CITY OF ALBUQUERQUE

**RE: WALH Towne Center Mass Grading
Grading Plan
Engineer's Stamp Date: 10/25/17
Hydrology File: J08D004**

Based on the information provided in the submittal received on 10/26/17 the above-referenced Grading Plan cannot be approved for Grading Permit until the following conditions are met:

WALK TOWNE CENTER
MASS GRADING PLAN

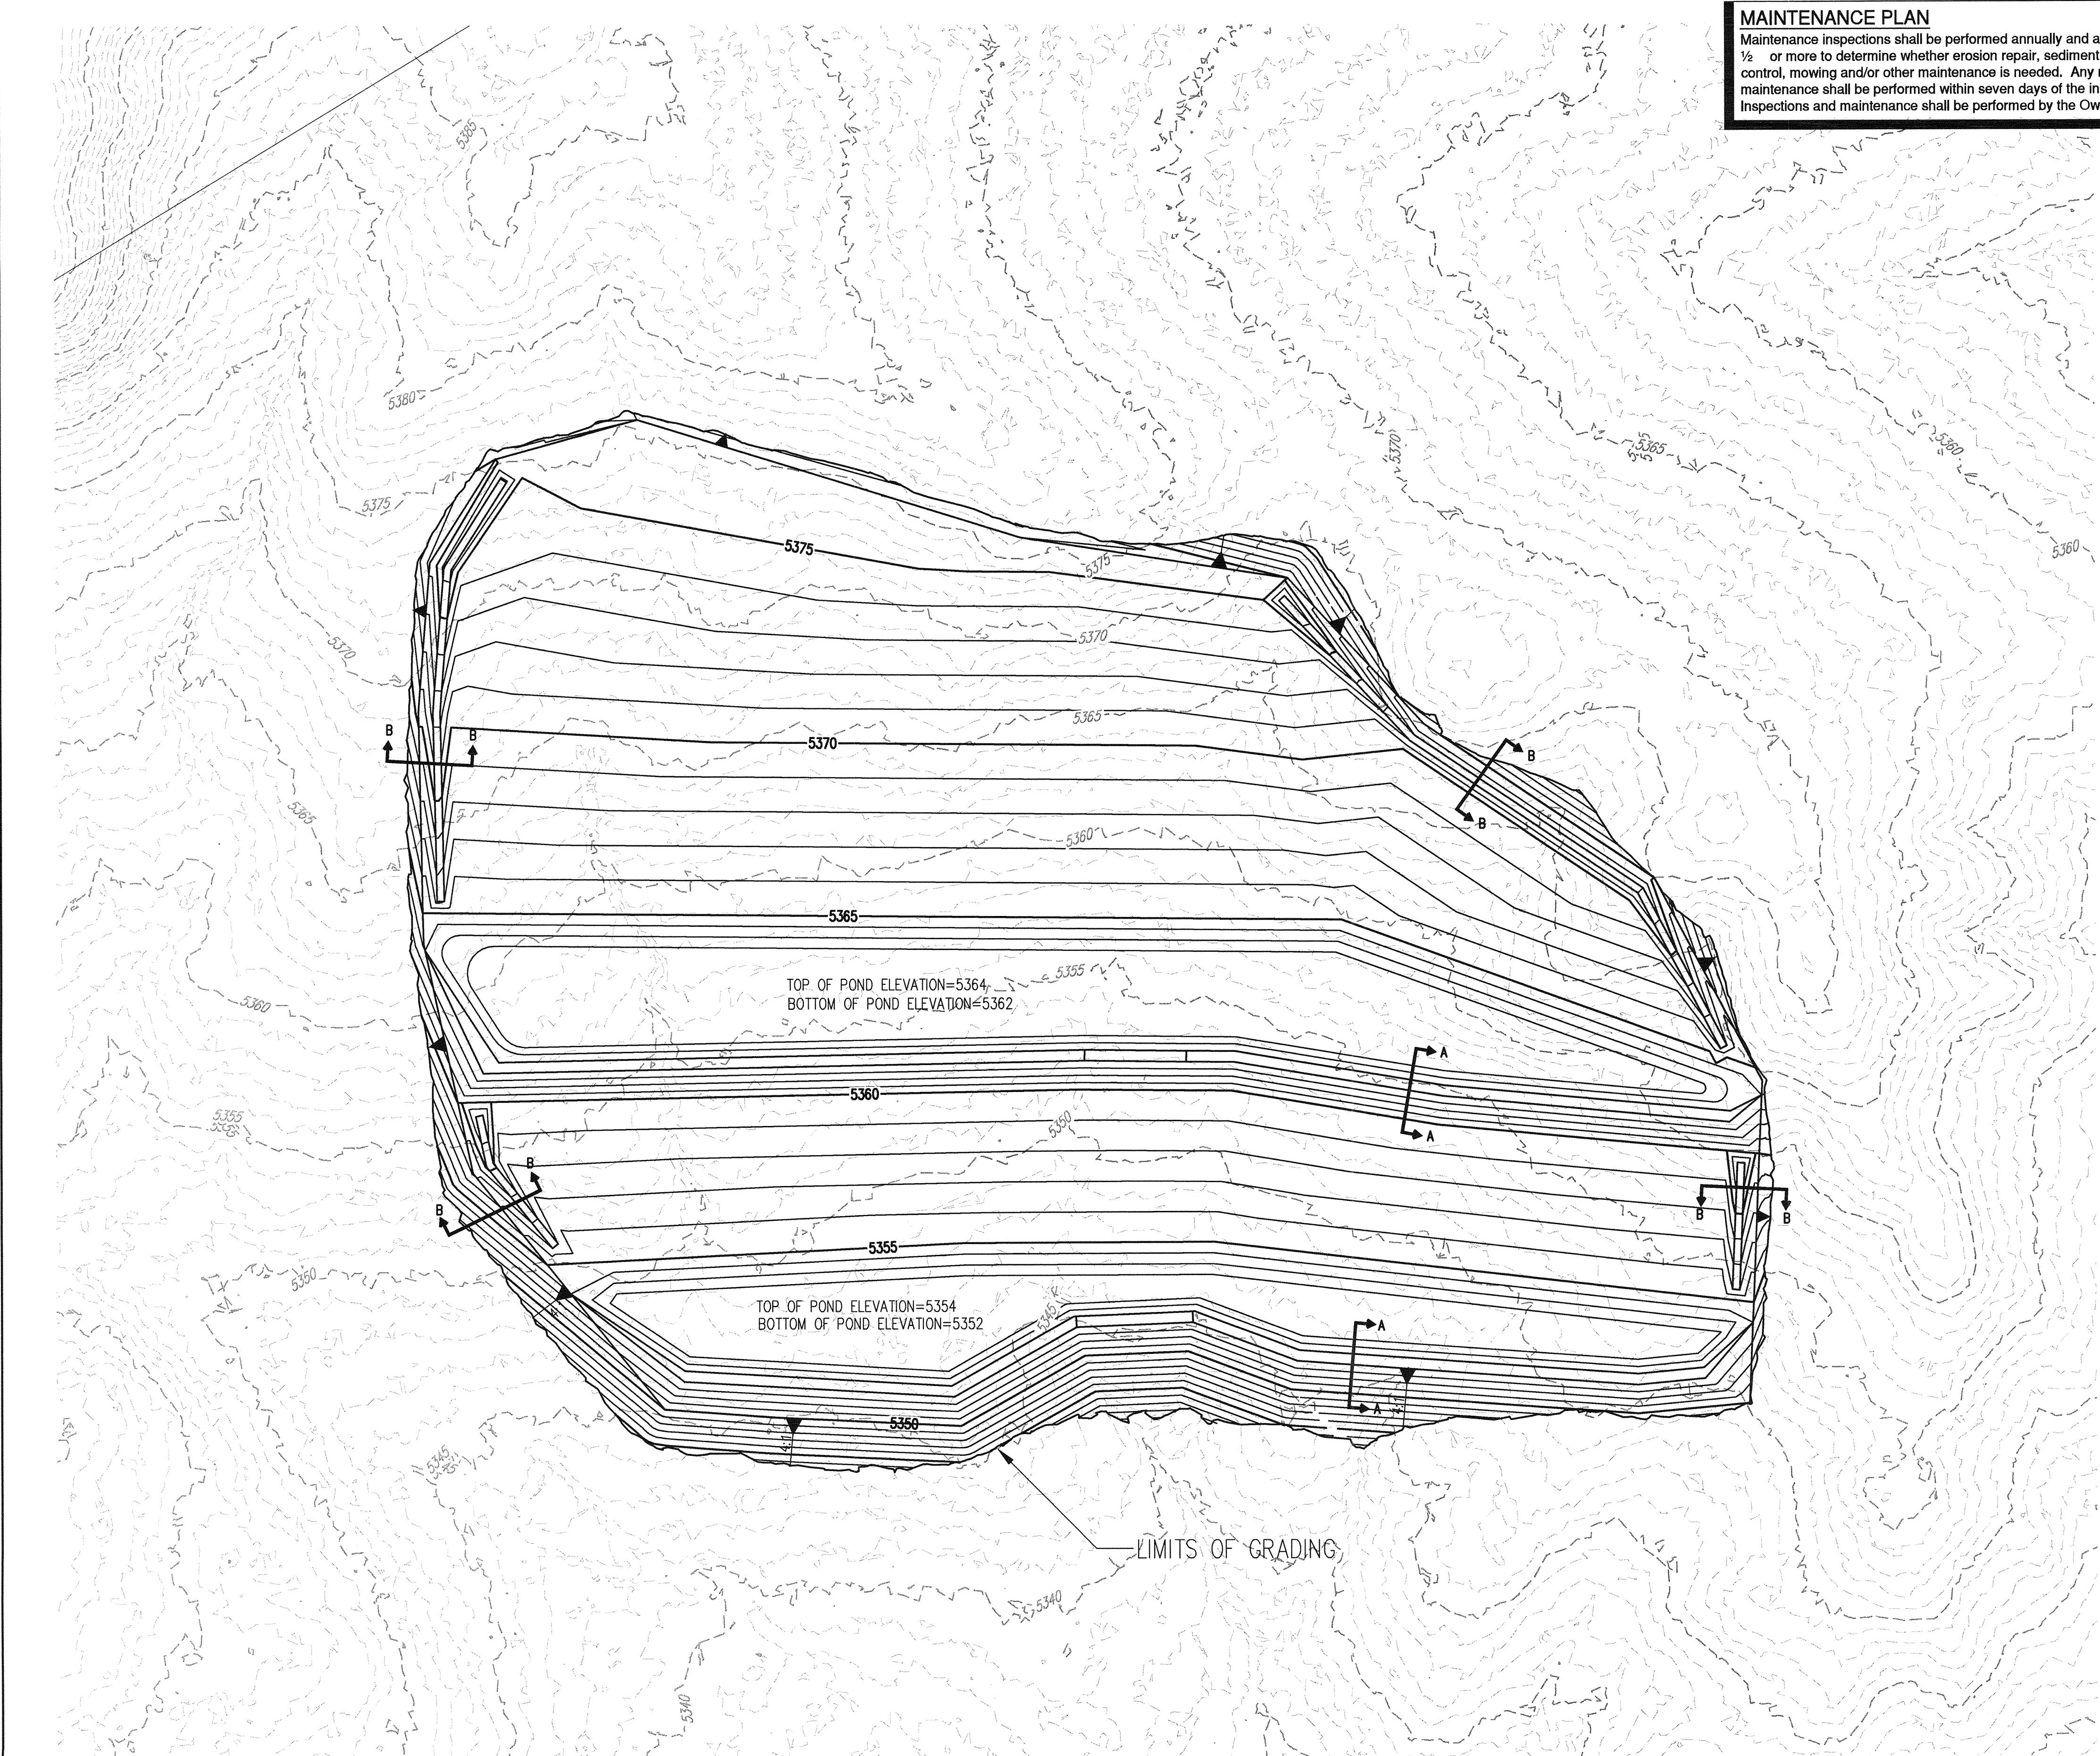
1. Section views A-A and B-B need to clearly define existing grade, fill, and compacted berm.
2. Compaction needs to be to 95%, extend to the subgrade, and include subgrade prep.
3. A maintenance plan needs to be included on the grading plan and include: inspections and interval, vector control, mowing, sediment removal, erosion repair, etc.
4. A Bernalillo County Recorded Private Facility Drainage Covenant is required for the ponds and maintenance of the stockpile. Please contact Charlotte LaBadie (clabadie@cabq.gov, 924-3996) or Madeline Carruthers (mtafoya@cabq.gov, 924-3997) regarding the routing and recording process for covenants.
